From: Raymond Cole [REDACTED]
Sent: 05 February 2018 19:28
To: Simon Davis
Cc: Stephen Fletcher; Michael Gadd; Stephen Bennett
Subject: Land at Kings Close, Yapton - Reserved Matters Application - Y/74/17/RES - Message 1 of 2

Principal Planning Officer's comments

PLOT 14 - 15 ELEVATIONS - SCALE 1:100
Drawing prepared for approval of reserved matters following Outline Planning Approval Y/22/14

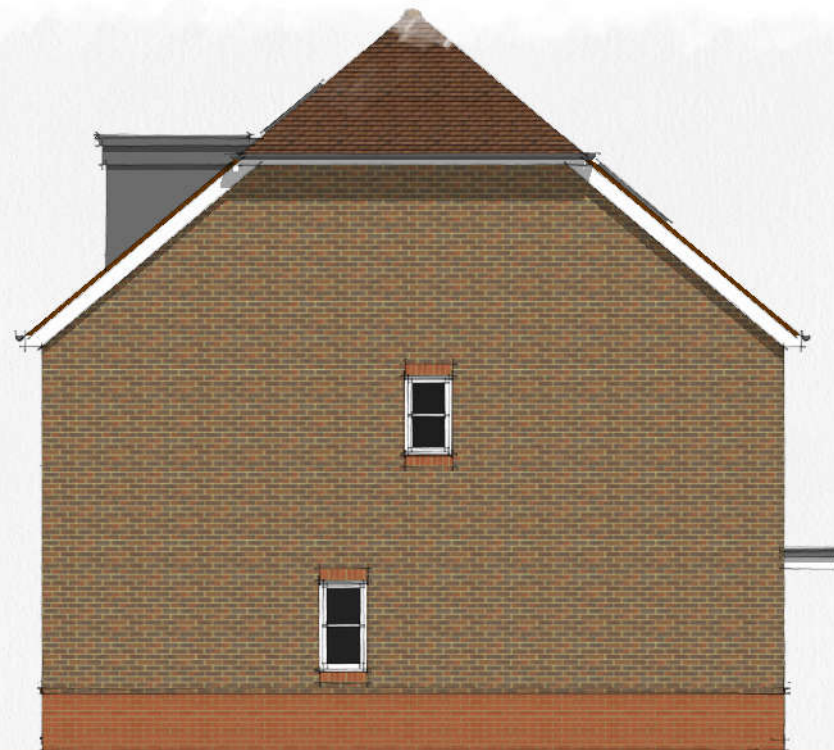
6. I have a concern re the interface between plots 14-15 and the eastern elevation of plot 16. The simplest way to resolve this would be to have the FF bathroom window in the eastern elevation off plot 16, obscure glazed and top vent opening only. Could an amended plan be provided with this indicated.

The drawings have been amended to show the window obscure glazed and with top vent opening only, as requested. Please see drawings numbered RM190 REVA and RM195 REVA.

BIN STORE TYPE A - SCALE 1:50

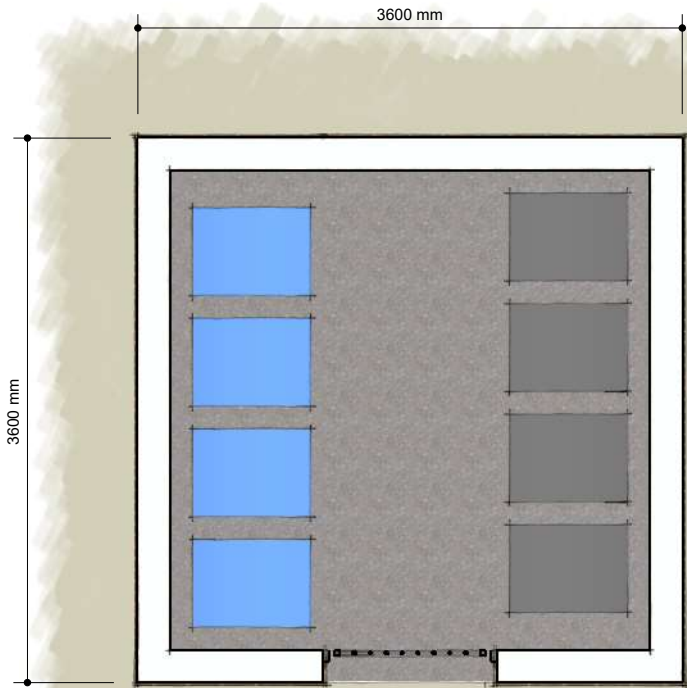
The two remote combined cycle/refuse bin stores must have vandal resistant PIR lighting installed internally and the front doors must be lockable. The cycle store should be completely separated from the bin store by a floor to ceiling divider. I refer to Section 53 of Secured by Design 'Safer Homes 2016' document for cycle storage specifications.

There are no combined cycle/refuse bin stores proposed as part of the development. The remote bin stores are for refuse only. Cycle stores are located in rear gardens only. The provision of PIR lighting and lockable doors has been noted on the drawings numbered RM117 REVA and RM118 REVA.

PLOTS 9 - 11 HOUSE PLANS - SHEET 1

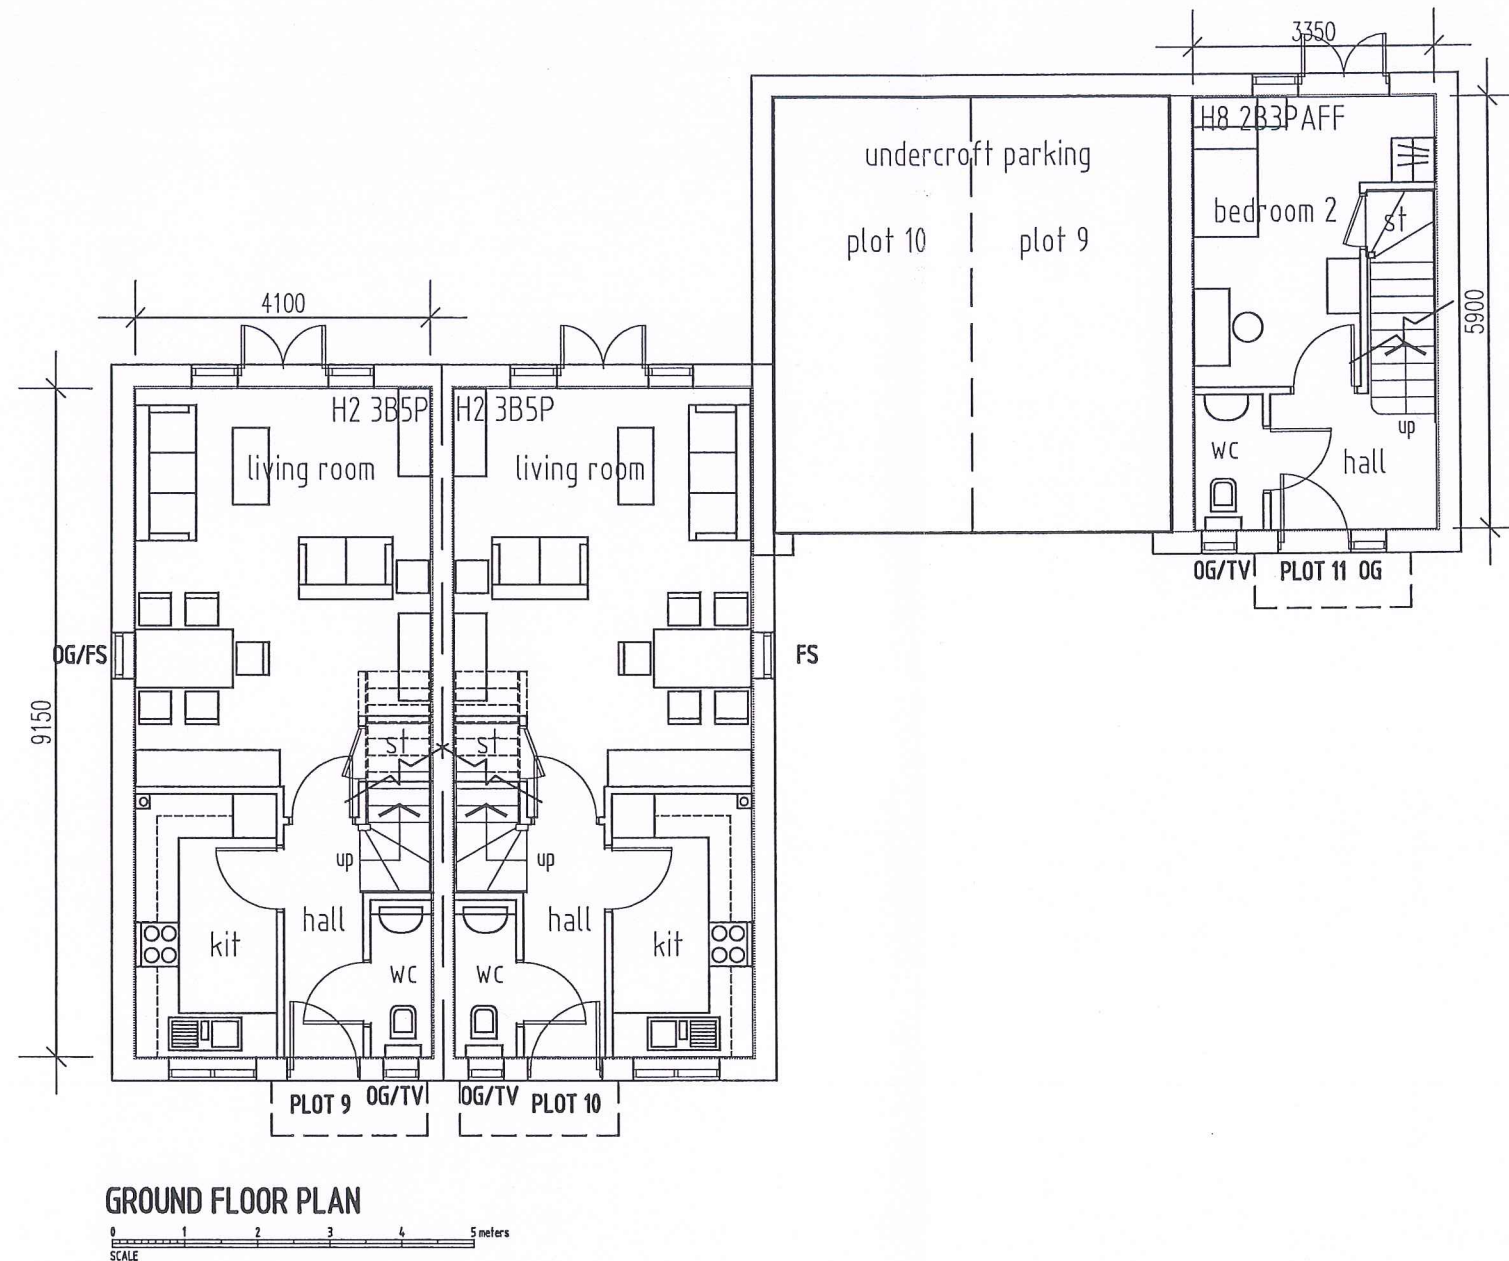
2. The FF window in the west elevation of plot 9 should be shown to be obscure glazed and with top vent opening only as otherwise it allows views of Connemara's rear garden. Could an amended plan be provided with this indicated.

3. The north elevation of plot 11 shows a kitchen window at FF which on plan is stated to be high level but isn't particularly so on the elevation. Can you clarify as I am concerned re overlooking of the FF lounge window on the S elevation of the existing flatted building.

The drawings have been amended to show the window obscure glazed and with top vent opening only, as requested. Please see drawings numbered RM151 REVA and RM156 REVA.

The 'high level' note has been removed from the first-floor plan to ensure consistency with the north elevation. Please see drawings numbered RM151 REVA and RM156 REVA.

PLOTS 9 - 11 ELEVATIONS - sheet 1 - SCALE 1:100

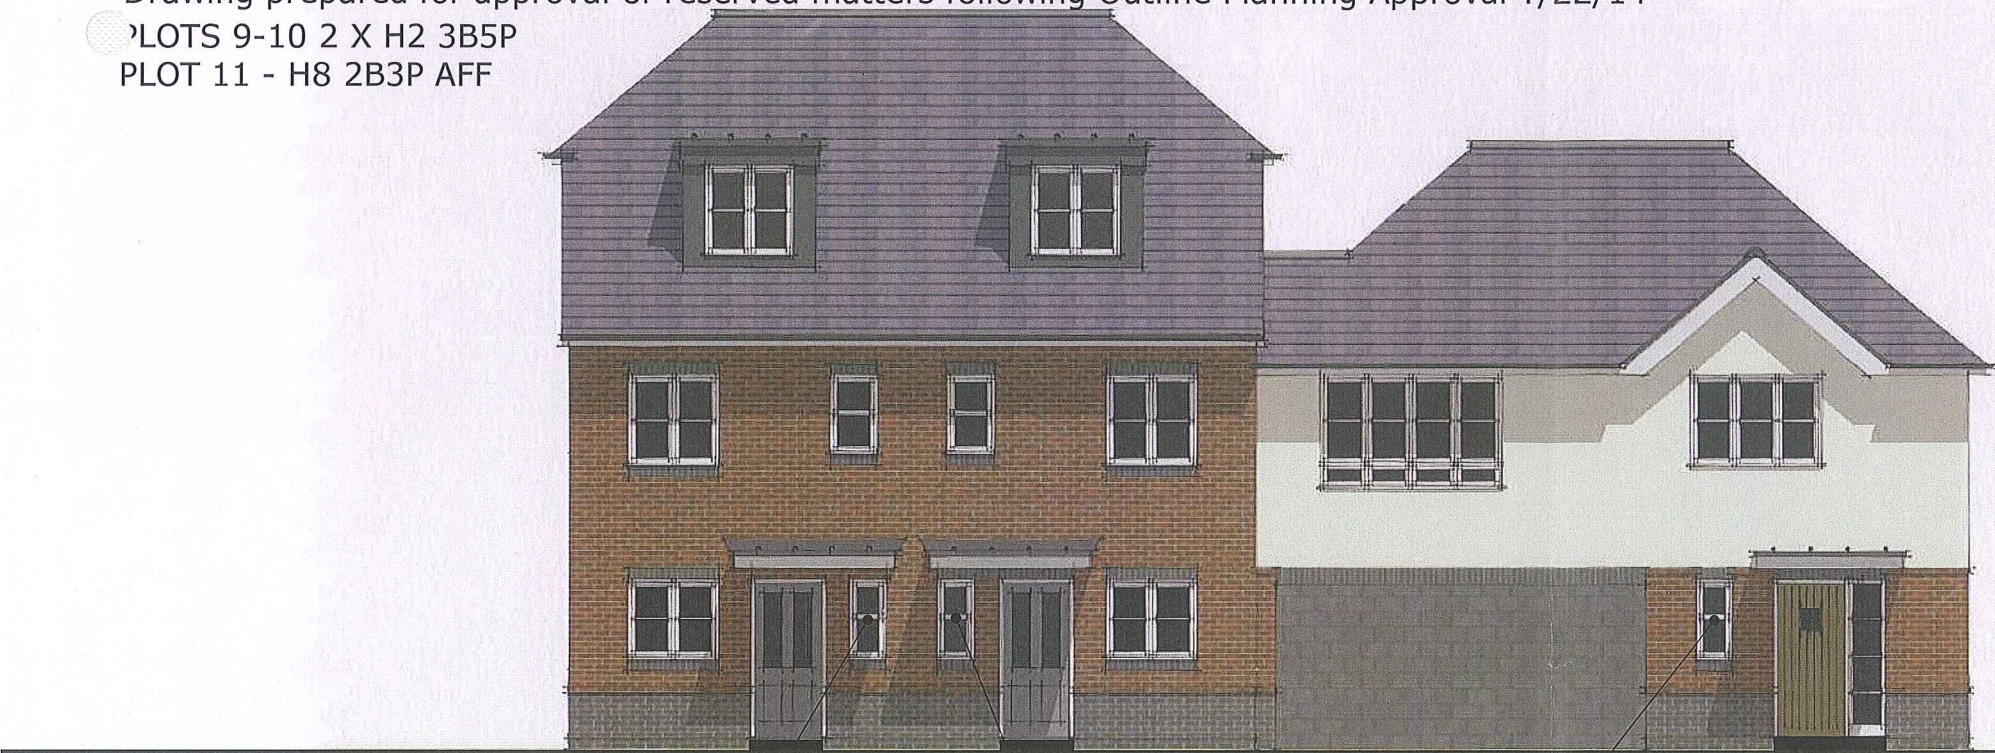
4. The front (south) elevation of plot 11 is shown to have a solid brick wall at GF which looks odd. Is this supposed to represent the rear wall of the undercroft parking? If so then that is fine.

Yes, this does represent the rear wall of the undercroft parking. However, the working drawings that have since been developed show that the timber frame above would benefit from support on a wall of 140mm facing blockwork. The

south elevation of plot 11 has therefore been amended to show facing blockwork, in place of brick, for the internal walls of the undercroft car park. Please see the drawing numbered RM155 REVA.
